Planning application: 2020/92067

**FORMER STILE COMMON INFANT AND NURSERY SCHOOL,
PLANE STREET, NEWSOME, HUDDERSFIELD, HD4 6DF**

ERECTION OF 30 DWELLINGS

Dated: August 12, 2020

PLOTS 29 AND 30 PLANS AND ELEVATIONS

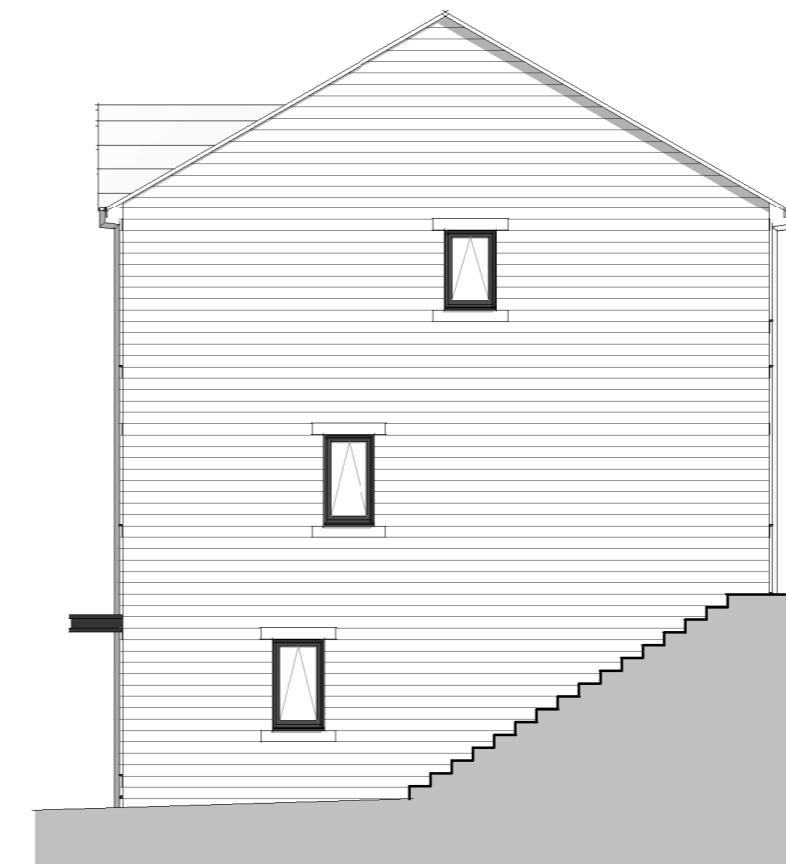
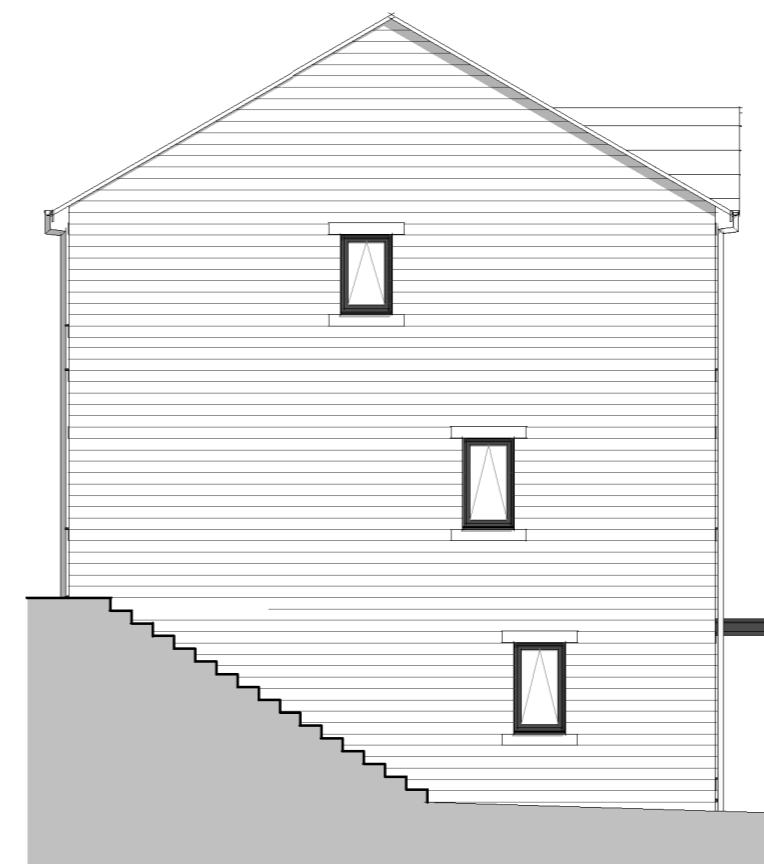
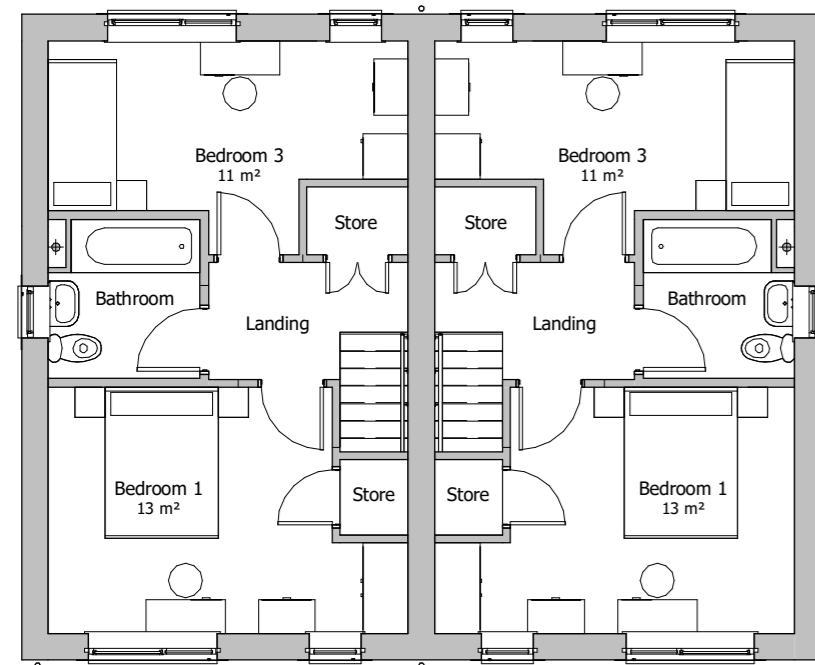
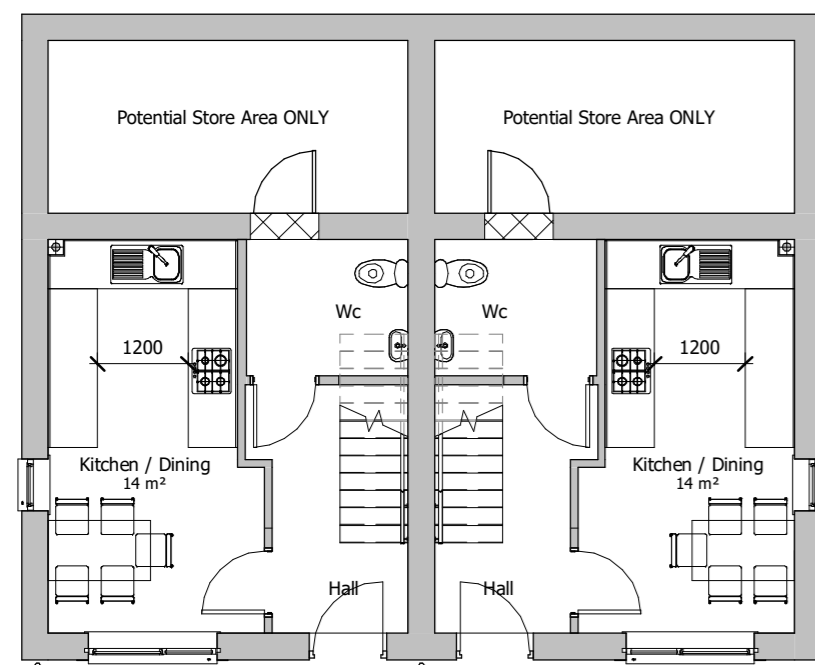
The proposed three-storey houses at the upper side of the new access may be more visible in the view than if they were two-storey, but are noted from the plan not to reach the highest part of the site with its mature trees.

However there remains beyond the upper row of three-storey houses 28 to 30.
